Rezoning Transportation Analysis
Petition Number: Insert Zoning Petition #2021-063
General Location Identifier: 14124101

From: Robyn Byers, Ph.D.
Robyn.Byers@charlottenc.gov
704-336-7404

Reviewer: Kevin Parker
Kevin.Parker@charlottenc.gov
704-432-6511

Date	Description
05-27-2021	First Review (KP)
06-24-2021	Second Review (KP)
07-26-2021	Third Review (KP)

## SITE PLAN

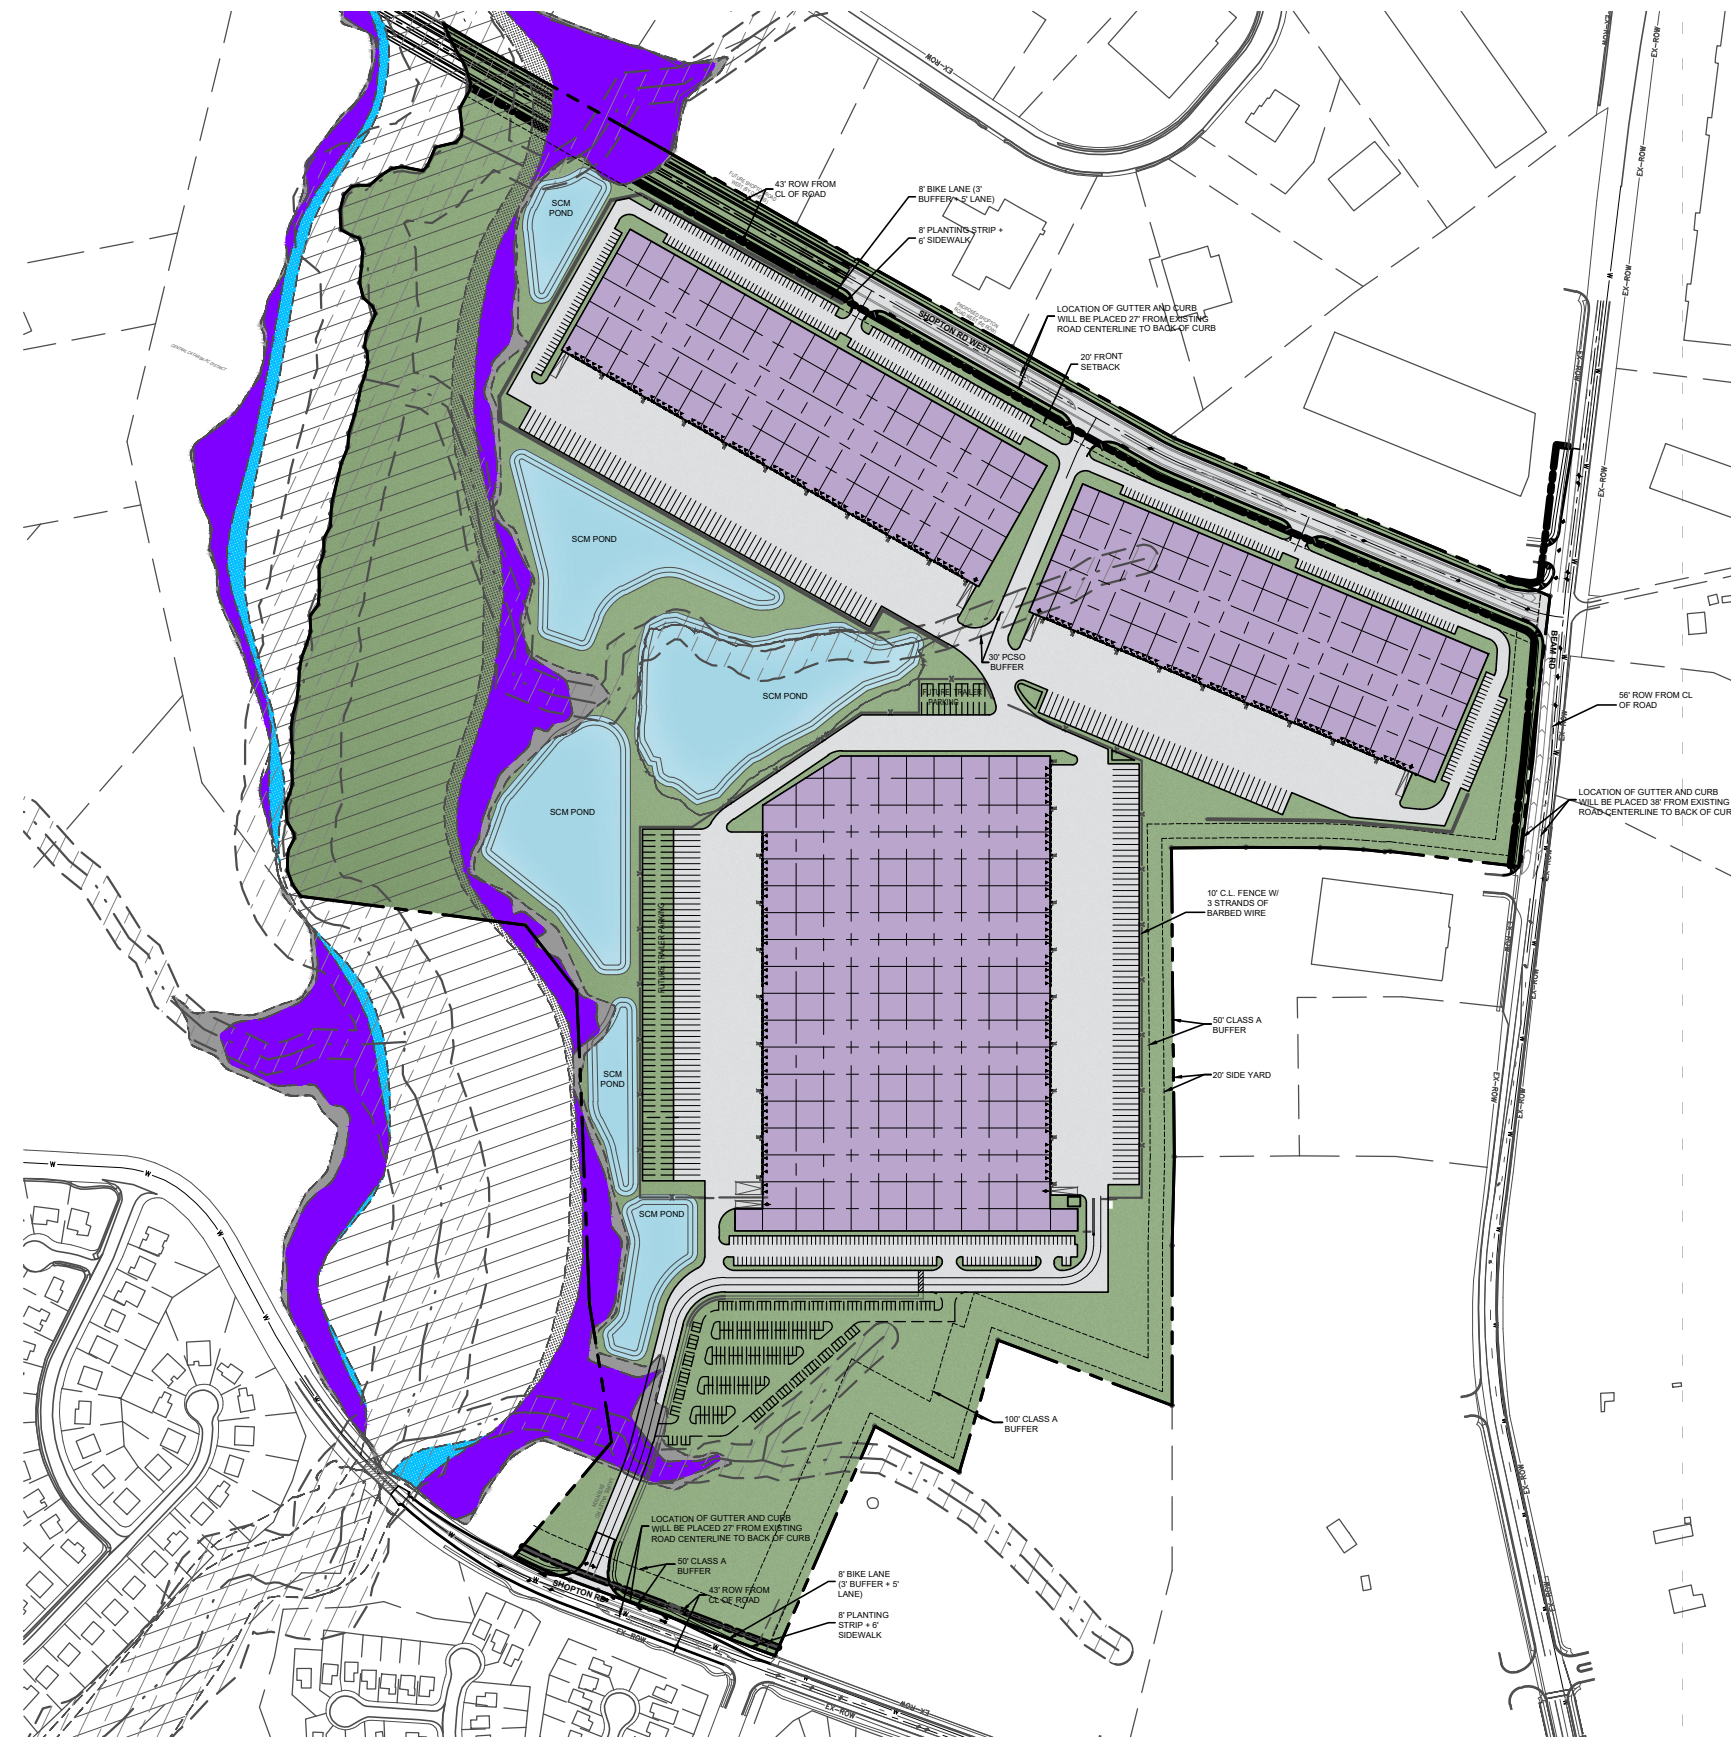
Update to Comment as a Result of the 06-16-2021 Site Plan: Label the total width associated with right-of-way dedication associated with the Shopton Road Extension.

Update to Comment as a Result of the 06-16-2021 Site Plan: Revise conditional note III.i by modifying the phasing of the Beam Road transportation improvements. All the transportation improvements on Beam Road shall be completed prior to the Shopton Road Extension is connected to Beam Road.

SITE PLAN

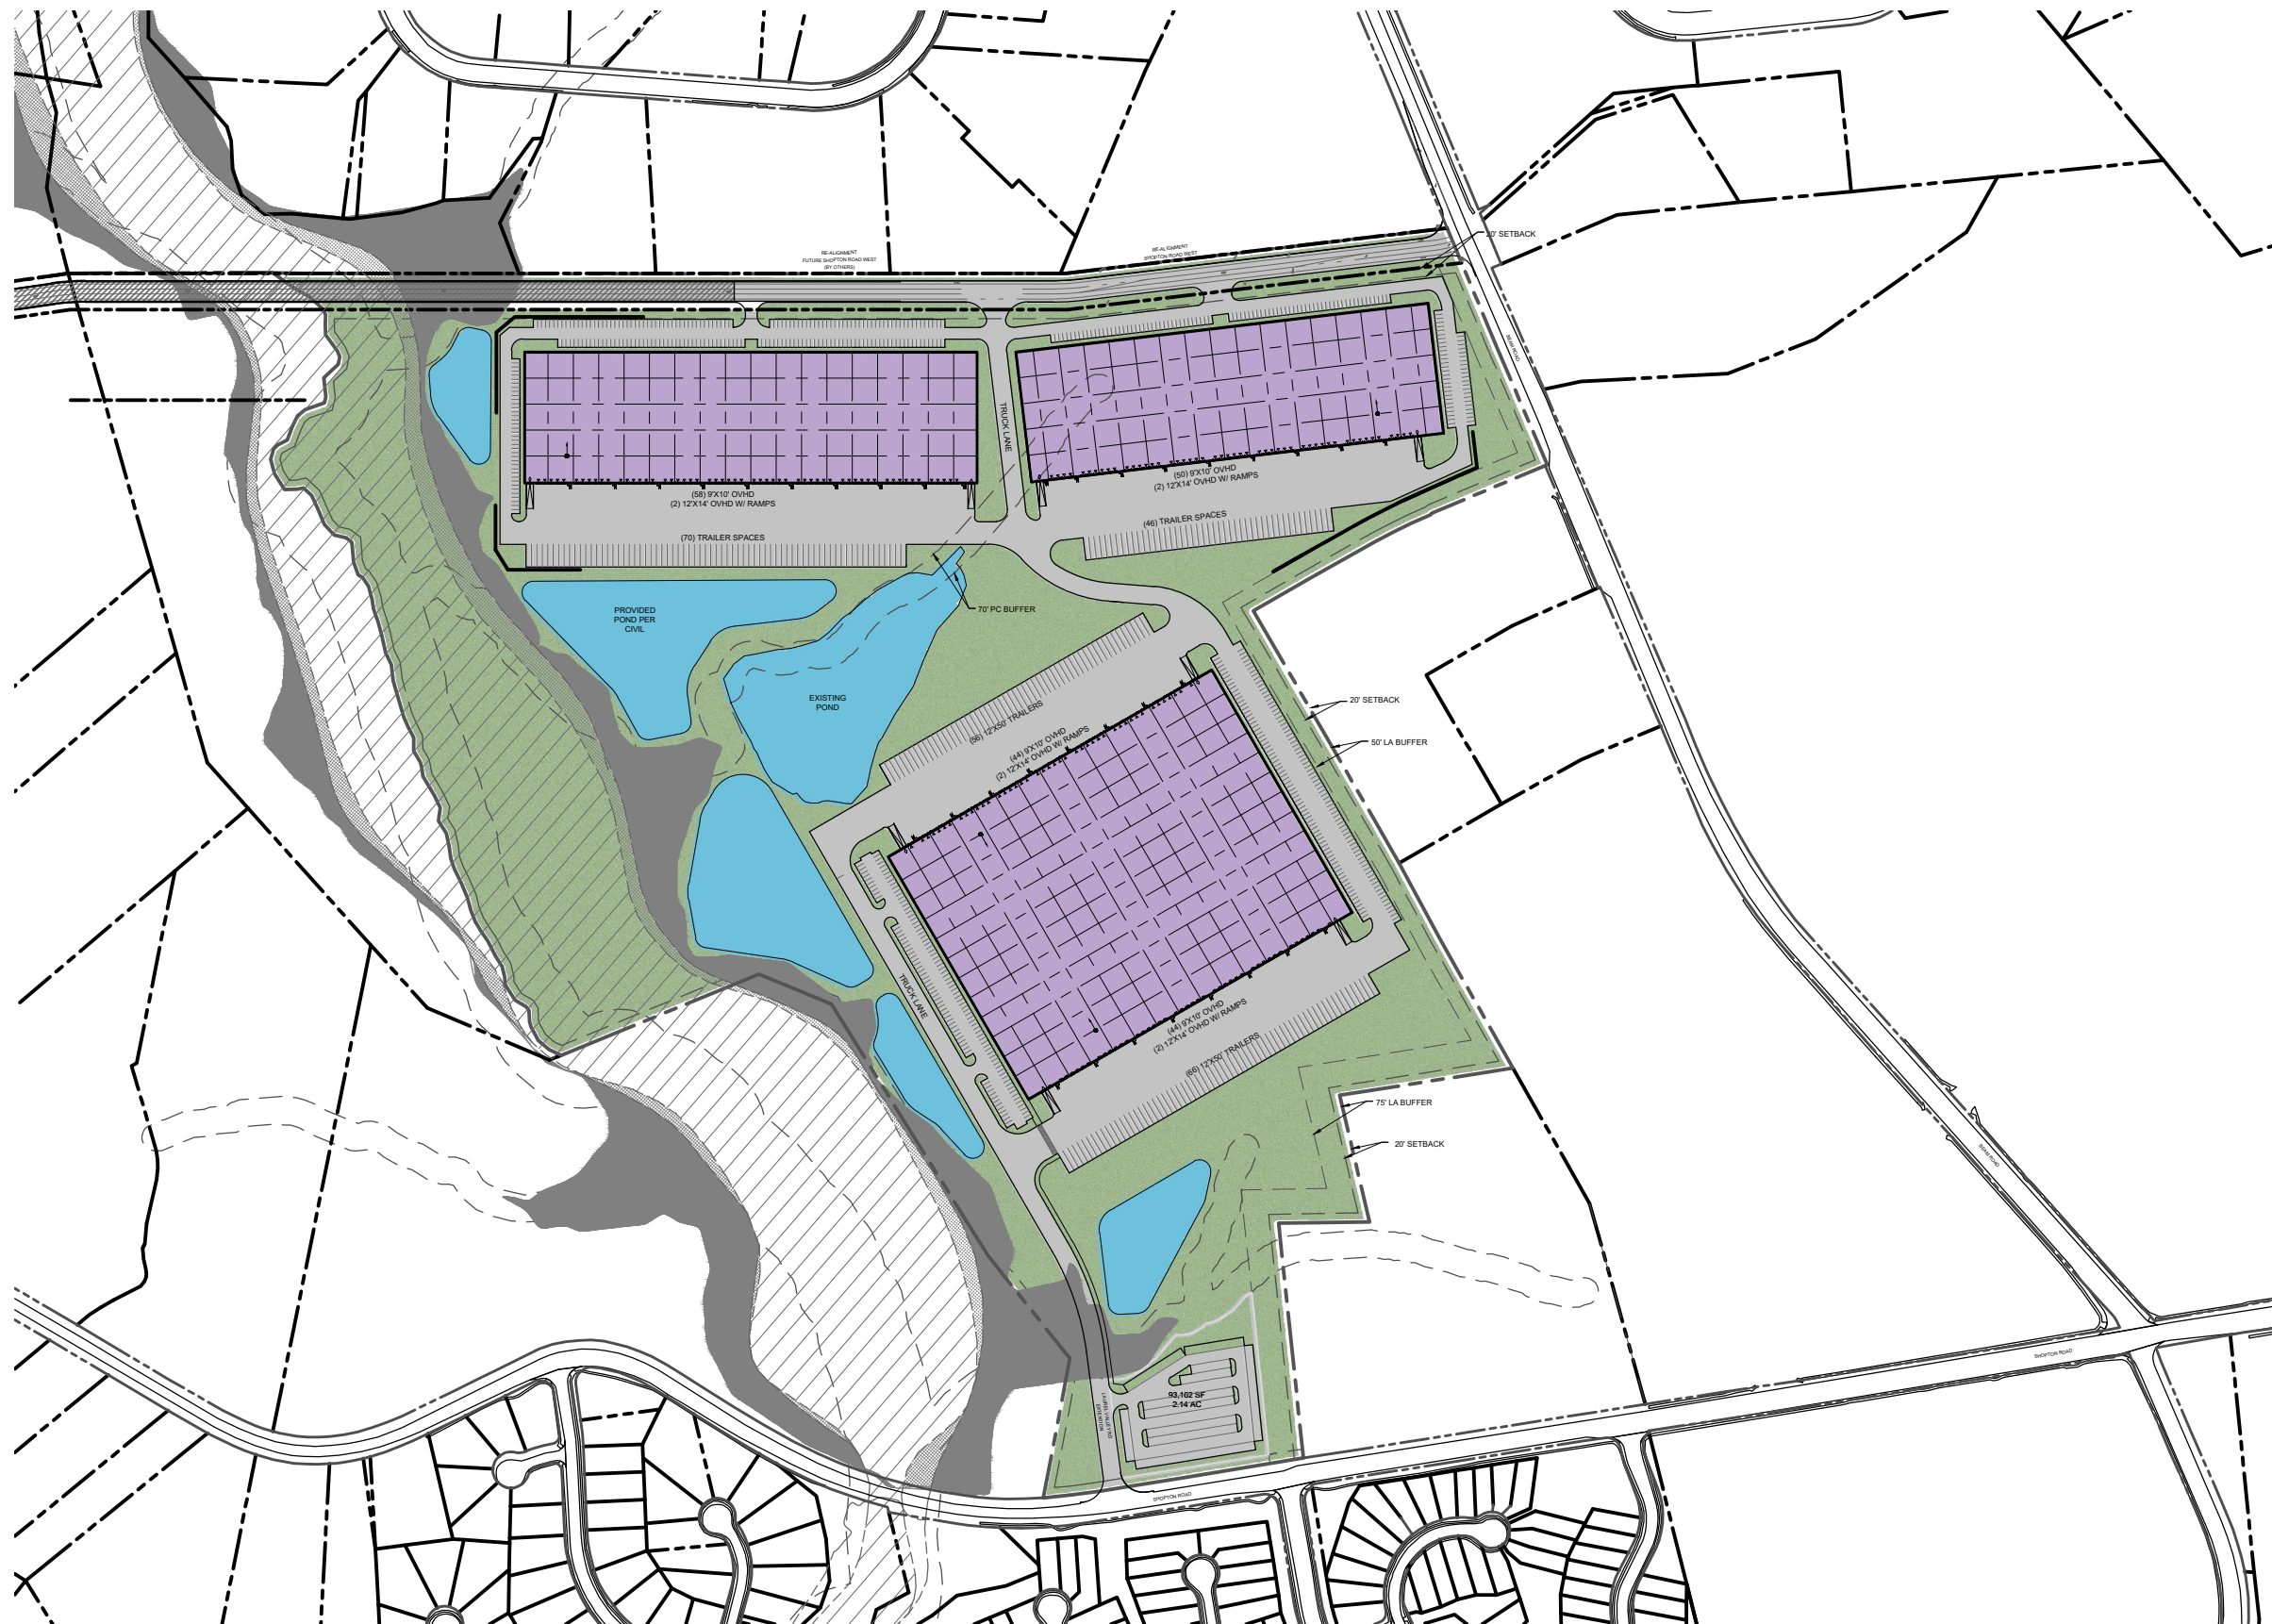
1. ~~**Curblines:**~~
 - a. ~~**Shopton Road:** The location of curb and gutter will be placed 27 feet from the existing road centerline to back of curb.~~
 - b. ~~**Beam Road:** The location of curb and gutter will be placed 38 feet from the existing road centerline to back of curb.~~

~~Label and dimension the curb and gutter from the centerline for each road on the site plan.~~

3. **Right-of-way:**
 - a. ~~**Shopton Road:** Revise site plan and conditional note(s) to commit to dedicate 43 feet of right-of-way from the road centerline.~~
 - b. ~~**Beam Road:** Revise site plan and conditional note(s) to commit to dedicate 56 feet of right-of-way from the road centerline.~~

~~The site plan shall label and dimension the right-of-way from the road centerline.~~

4. ~~Revise site plan and conditional note(s) to commit to construct an 8-foot planting strip, and 6-foot sidewalk along the site's frontage of Shopton Road and Beam Road, per City Ordinance Chapter 19. The site plan shall label and dimension both items from the existing road centerline.~~

5. ~~Revise the site plan and conditional notes to commit to constructing 8-foot buffered bike lanes (3-foot buffer and 5-foot lane) along the site's frontage of Shopton Road and Beam Road. The site plan shall label and dimension the bike lane from the existing centerline of each road.~~

6. ~~Revise the site plan and conditional notes to commit to constructing a left turn lane **and** right turn lane, with 150 feet of storage and appropriate bay taper length, at the proposed site entrance located on Beam Road. Additionally, include in the conditional note that the turn lanes will be designed and striped in accordance with the City of Charlotte's Pavement Marking Guidelines.~~

- 7. ~~Revise the site plan and conditional notes to commit to widen Beam Road 38 feet from the existing centerline to back-of-curb, along the site's frontage. Additionally, revise the striping along Beam Road to incorporate a three-lane section with the buffered bike lanes striped along the edge of pavement. Any additional asphalt shall utilize transverse striping, in accordance with the City's Pavement Marking Standards, to delineate the travel lane and the buffered bike lane.~~

- 8. ~~Revise the site plan and conditional notes to commit to constructing a left turn lane **and** right turn lane, with 150 feet of storage and appropriate bay taper length, at the proposed site entrance located on Shopton Road. Additionally, include in the conditional note that the turn lanes will be designed and striped in accordance with NCDOT's Roadway Design Manual.~~

- 9. ~~Revise the site plan and conditional notes by committing to coordinate driveway location and site access associated with PID# 14106101. CDOT recommends moving the driveway location to the~~

- 10. ~~Revise the site plan and conditional notes to commit to construct a portion of the Shopton Road Extension CTP Alignment, as generally depicted on the site plan. Additionally, provide the cross section, associated with the Shopton Road Extension, that includes dimensions of the proposed infrastructure and the right of way to be dedicated to CDOT.~~

- 11. ~~Revise the site plan and conditional notes by committing to dedicate the right-of-way for the future segment the Shopton Road Extension, that will not be constructed with this development, to CDOT. The amount of right of way dedication should be proportionate with the cross section established in Note 10 of this memo.~~

- 12. ~~Revise the site plan and conditional notes to commit to coordinate with Mecklenburg County Parks and Recreation and construct the portion of the Coffee Creek Greenway that extends through this site.~~
